SADDLEHORN RANCH FILING NO. 1

A PARCEL OF LAND LOCATED IN THE SOUTH HALF OF SECTION 3 AND THE NORTH HALF OF THE NORTH HALF OF SECTION 10, TOWNSHIP 13 SOUTH, RANGE 64 WEST OF THE 6TH PRINCIPAL MERIDIAN EL PASO COUNTY, STATE OF COLORADO

SADDLEHORN RANCH FILING NO. 1
JOB NO. 25142.01
SEPTEMBER 18, 2019
SHEET 2 OF 4

FinalPlat_v2.pdf Markup Summary

# SADDLEHORN RANCH FILING NO. 1

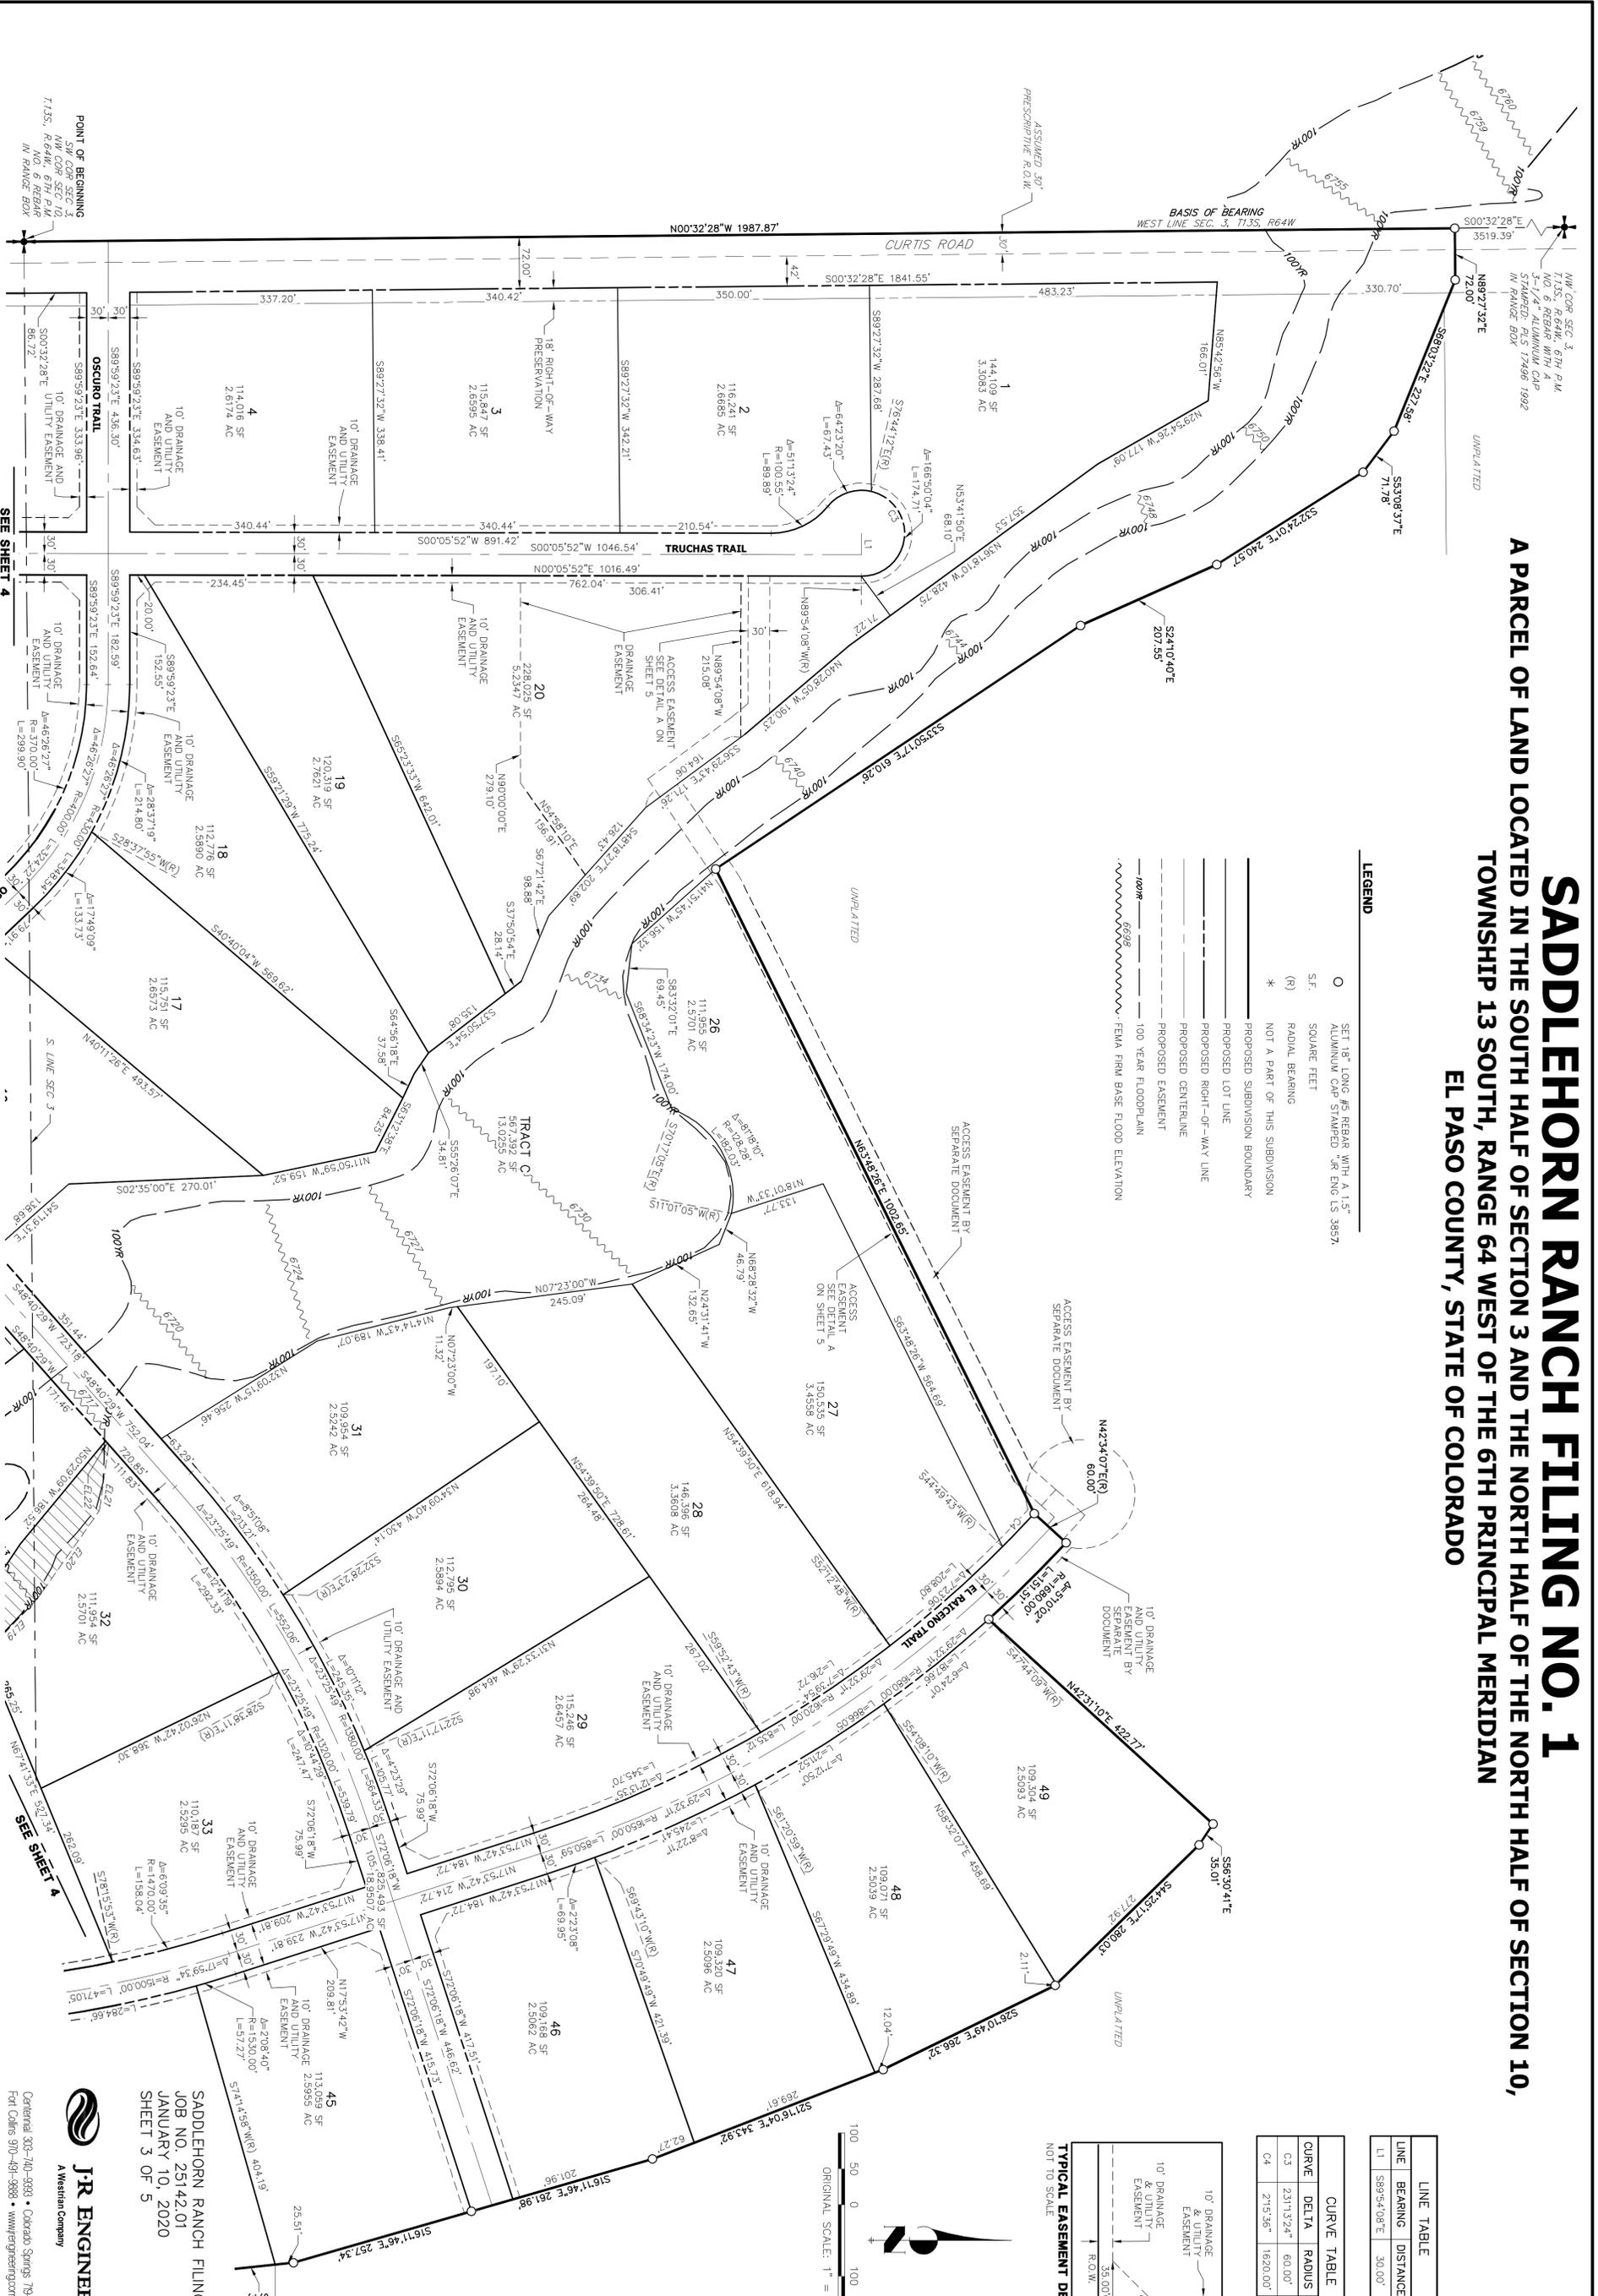
the remainder
area must be
platted as a
tract for future
development.

the remainder area must be platted as a tract for future development.

See comment on drainage report concerning Tract C. The T6 drainage way. Call out in the dedication language to El Paso County that 824 Acre Metro District will be responsible for maintaining the vegetation on this tract, i.e. mowing, weed control seeding etc.

See comment on drainage report concerning Tract C. The T6 drainage way. Call out in the dedication language to El Paso County that 824 Acre Metro District will be responsible for maintaining the vegetation on this tract, i.e. mowing, weed control seeding etc.

Provide a note that restricts lot coverage to no more than 10,900 Sf per lot to conform with the EL Paso County's MS4 Storm water discharge permit.

Provide a note that restricts lot coverage to no more than 10,900 Sf per lot to conform with the EL Paso County's MS4 Storm water discharge permit.

# SADDLEHORN RANCH FILING NO. 1

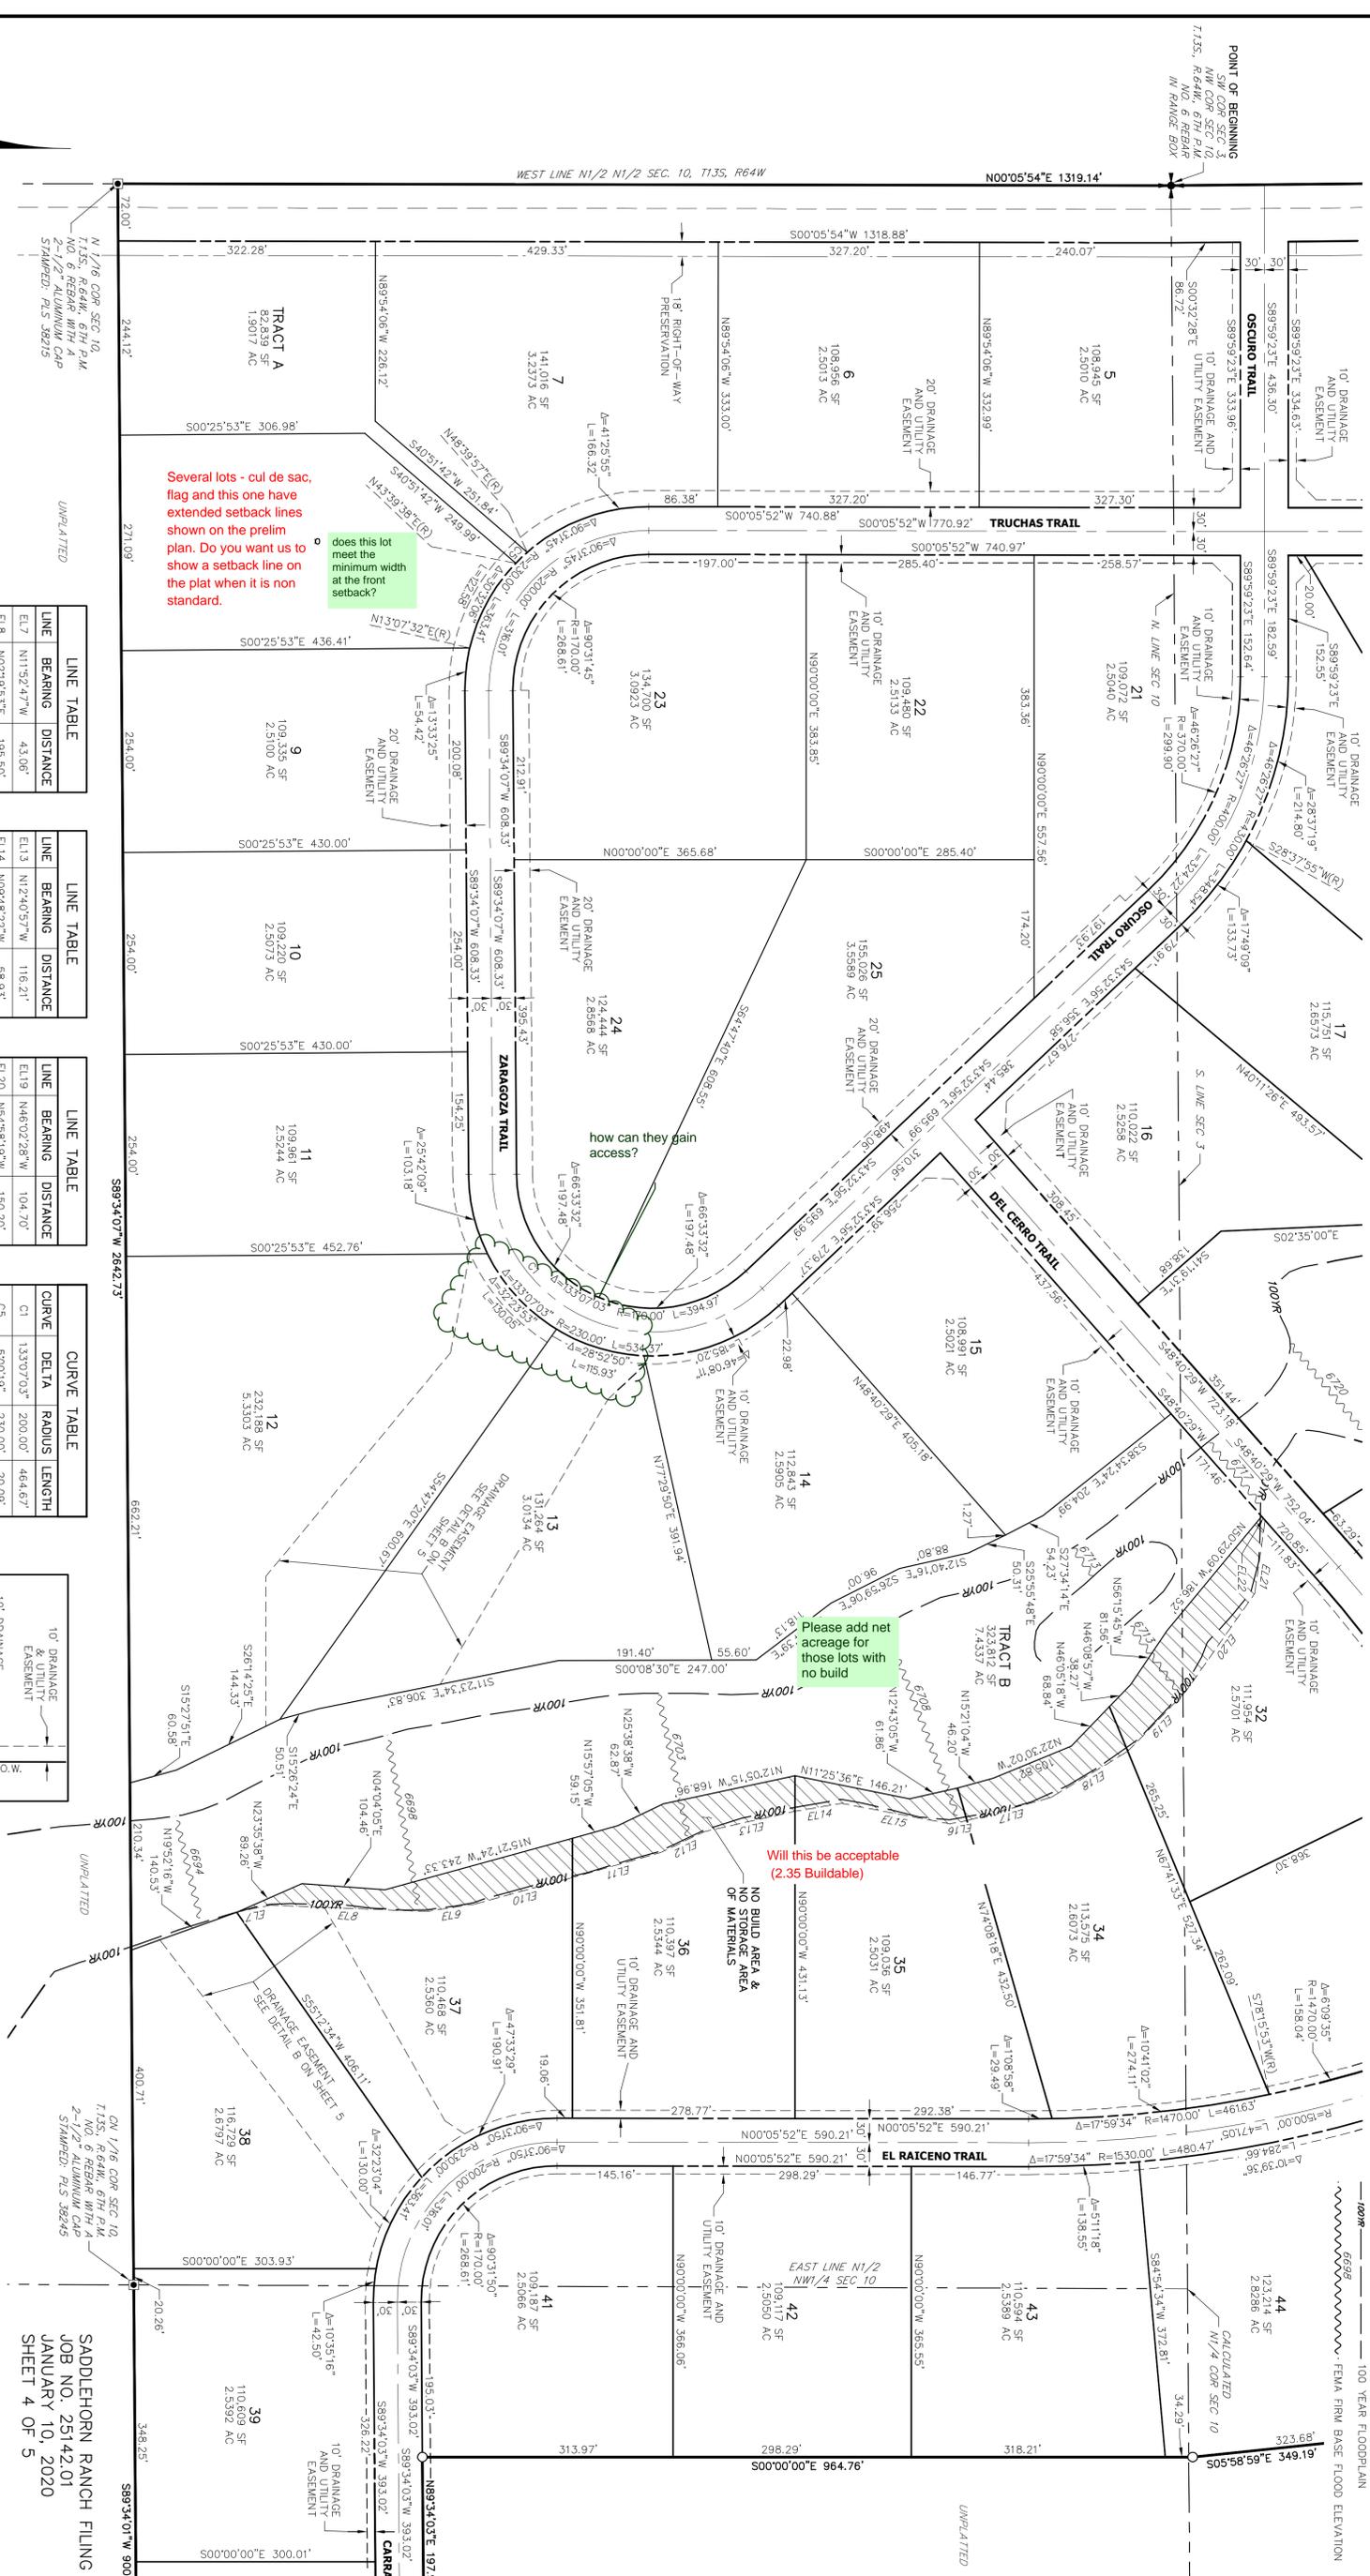
2 access points are required for lots in excess of 25.

2 access points are required fro lots in excess of 25.

setback line for 200' width

setback line for 200' (REVIEW ALL LOTS)

Include the drainage area in the Plat

# SADDLEHORN RANCH FILING NO. 1

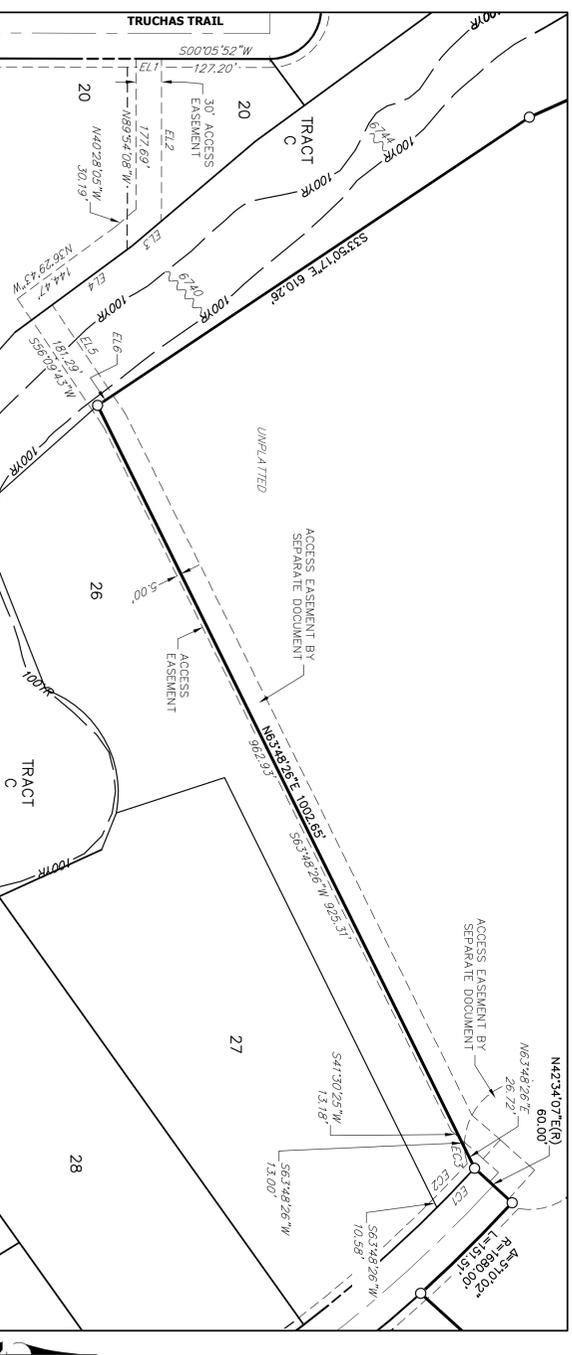
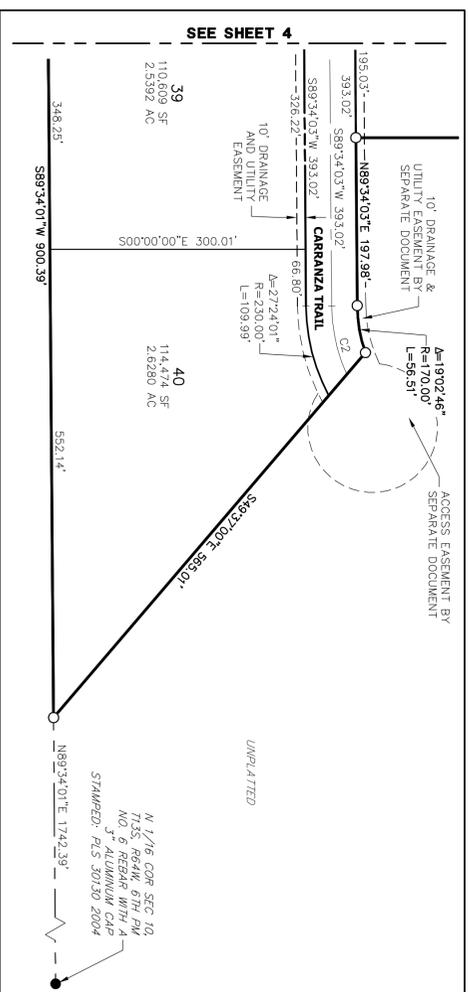
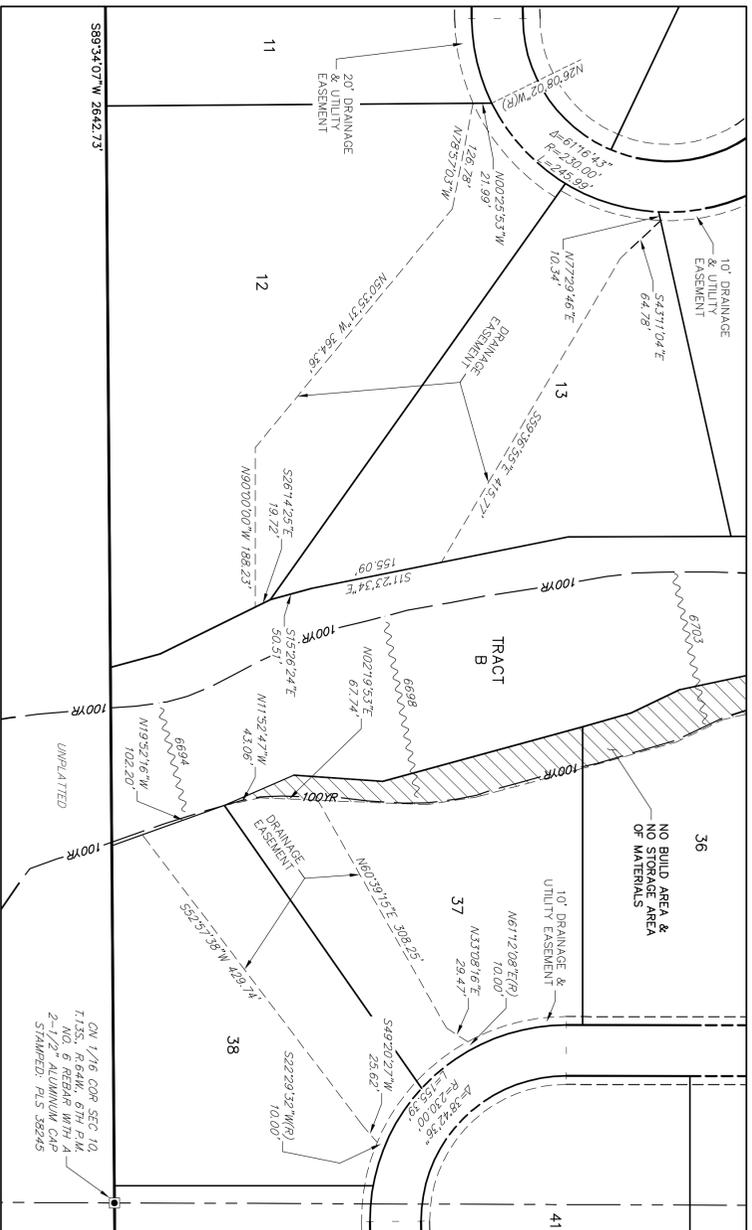
Where is Lot 52?

Where is Lot 52?

how can they gain access?

this matches the lot line type. Please revise
